**From:** [REDACTED]  
**Sent:** 15 August 2017 09:01  
**To:** Planning  
**Subject:** Planning application 6/2017/1286/FULL - The Sun Inn

**Response to Planning application from Hertfordshire County Council (T and CP GDP Order 2015)**

**Location**  
The Sun Inn  
Northaw  
Potters Bar  
EN6 4NL

**Proposal**  
Erection of a single storey rear extension and the removal of rear chimney following demolition of existing porch and store rooms

Drawing No. 304-PL-02	Rev B
---------------------------------	-----------------

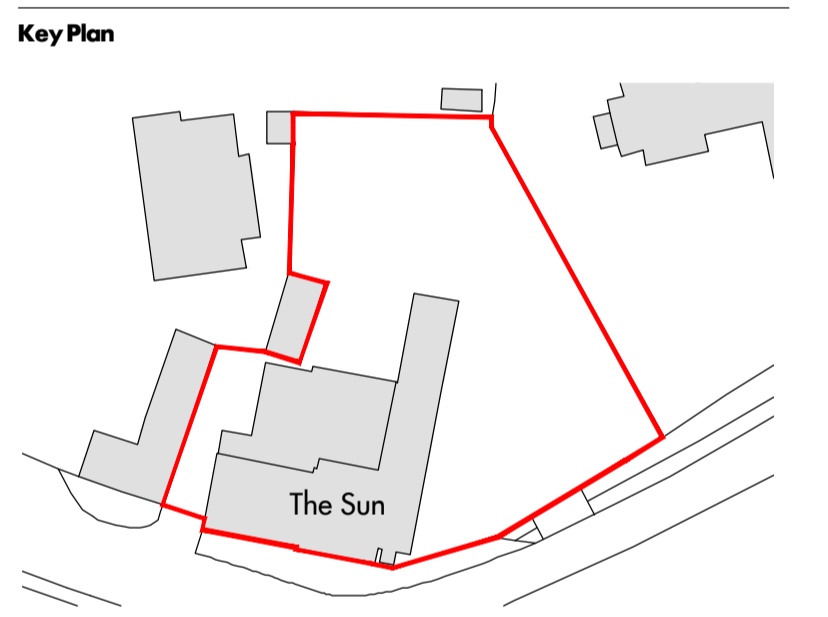
Revised details include block plan (Drwg 304-PL-02 Rev B).

Bin store is relocated to a point further within the site curtilage but remains an acceptable distance from point of collection, and unlikely to be of any detriment. Plans now omit the large structure proposed for the rear, and now remove 127m<sup>2</sup>.

Car parking layout, and access remains unchanged to the earlier submission, and I consider that comments provided 5/7/17 remain appropriate. The loss of the additional floor space would reduce the potential parking shortfall, however there remains a potential that investment will result in additional custom to the public house, and any potential shortfall in parking would continue to benefit from the recommended waiting restrictions to the junction of Northaw Road West and Vineyards in order to ensure that no inappropriate, unsafe or obstructive on-street parking will occur in the vicinity of this junction.

I therefore recommend that my earlier comments remain applicable.
